HYDRANT CONDITION CONSULTATION WITH PLANNING AUTHORITY

Planning Ref: CM/53/20/PL

Address: Land at Wren Cottage, Horsemere Green Lane, Climping,
BN17 5QZ.

Description: Development of 2 No 2-bed & 2 No 3-bed detached dwellings
& associated works. This site is in CIL Zone 3 and is CIL Liable
as new dwellings.

SITE PLAN
SCALE 1:500 @ a3

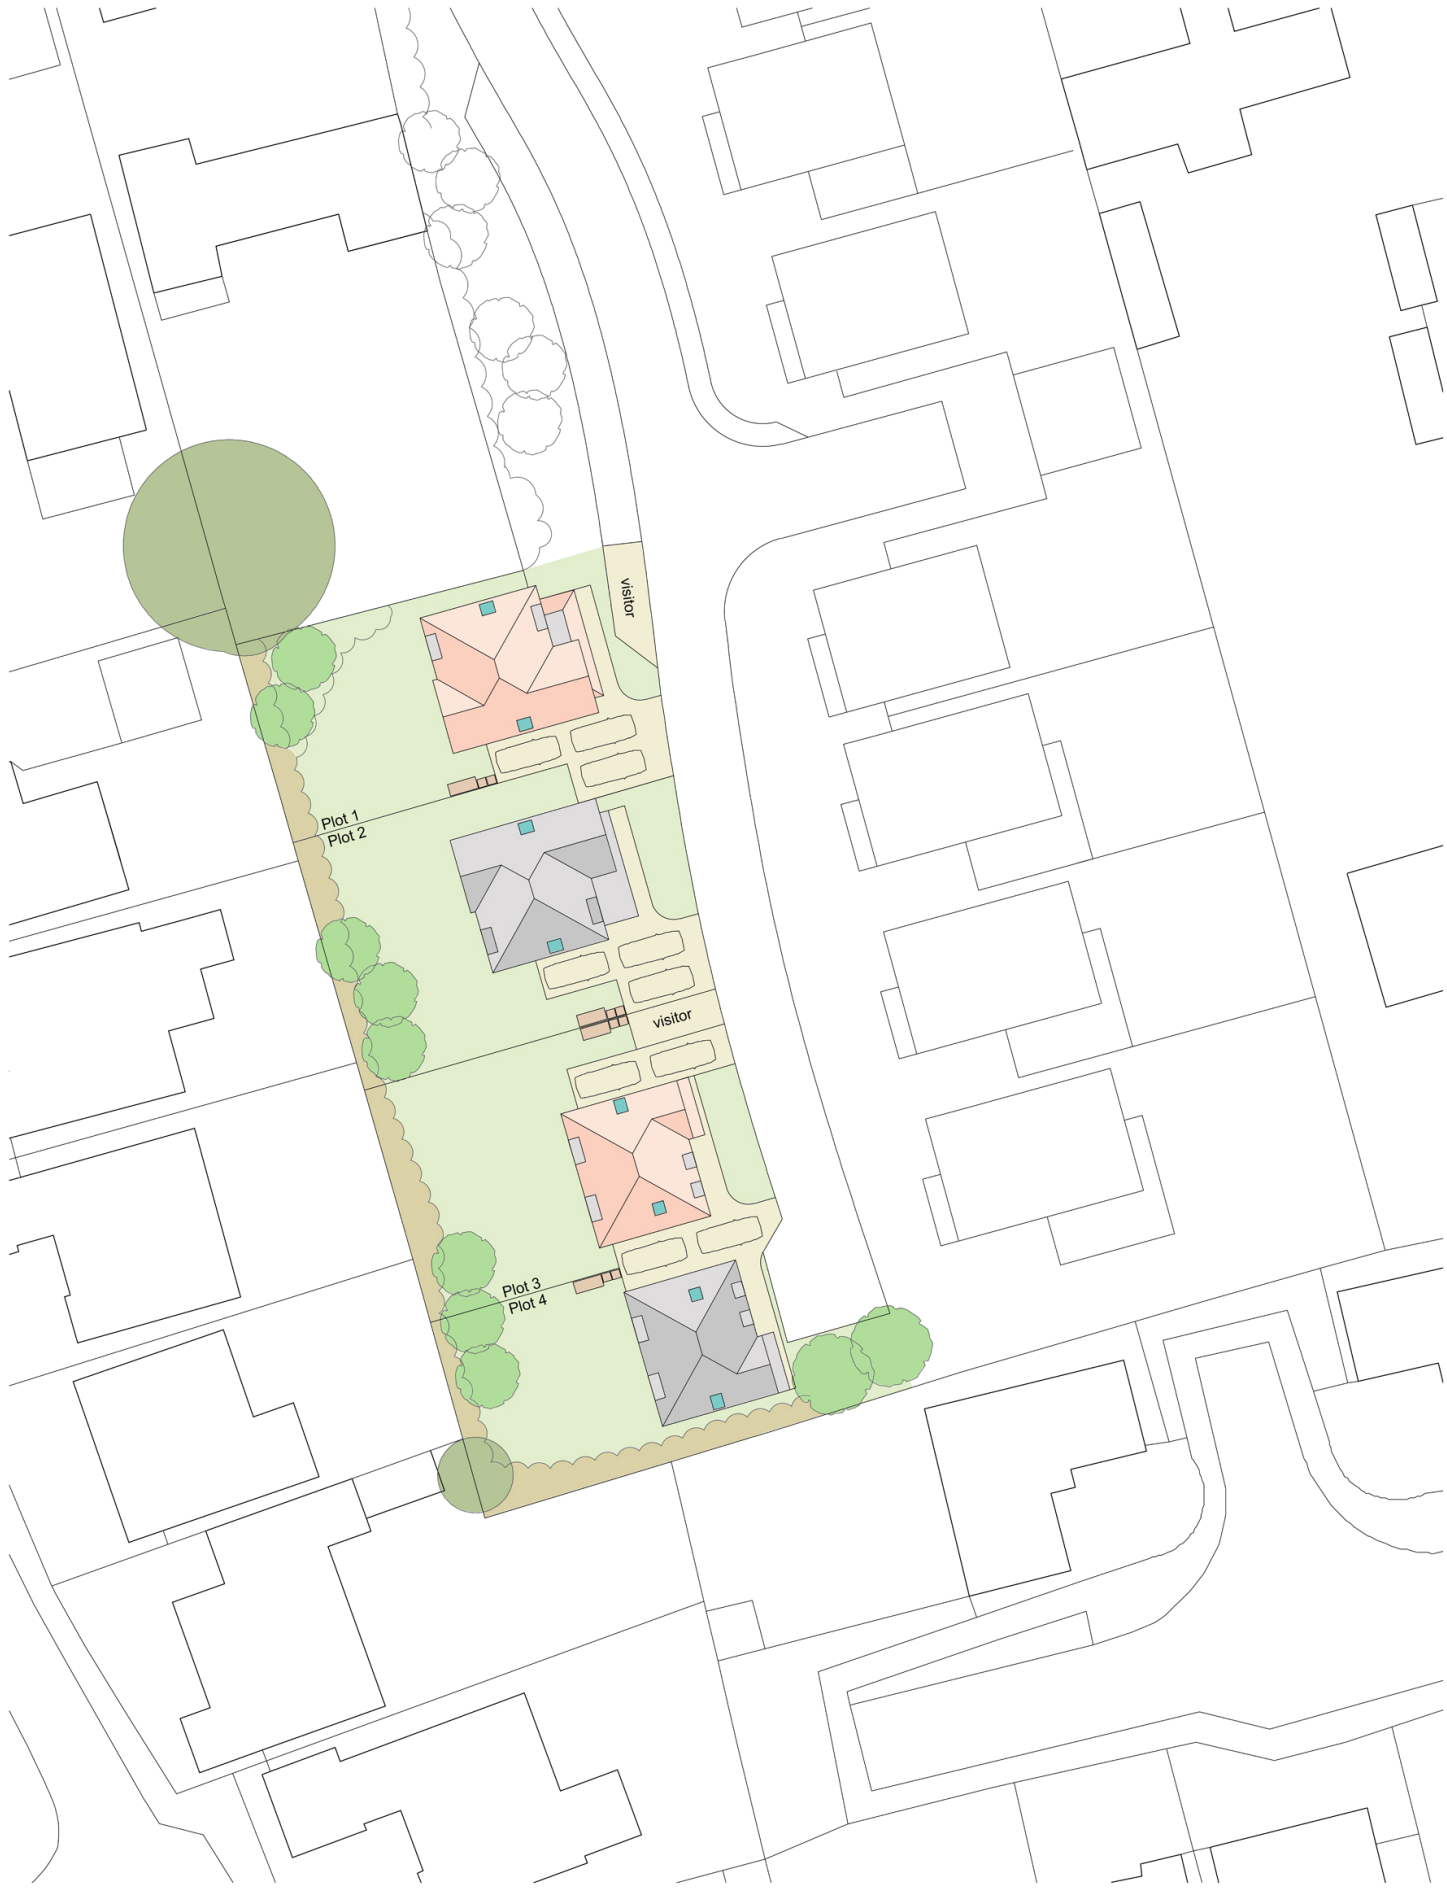
Please find attached a planning condition for application no. CM/53/20/PL for the requirement of an additional fire hydrant. Currently the nearest Hydrant to these proposed properties is 240 metres away. The supply of water for firefighting for a domestic premises should be within 175 metres.

Evidence will also be required that Fire Service vehicle access meets with the requirements identified in Approved Document B Volume 1 2019 Edition: B5 Section 13, including Table 13.1 and diagram 13.1.

- 1) Prior to the commencement of the development details showing the proposed location of [1] one fire hydrant or stored water supply (in accordance with the West Sussex Fire and Rescue Guidance Notes) shall be submitted to and approved in writing by the Local Planning Authority in consultation with West Sussex County Council's Fire and Rescue Service. These approvals shall not be unreasonably withheld or delayed.
- 2) Prior to the first occupation of any dwelling/unit forming part of the proposed development that they will at their own expense install the fire hydrant (or in a phased programme if a large development) in the approved location to BS 750 standards or stored water supply and arrange for their connection to a water supply which is appropriate in terms of both pressure and volume for the purposes of firefighting.
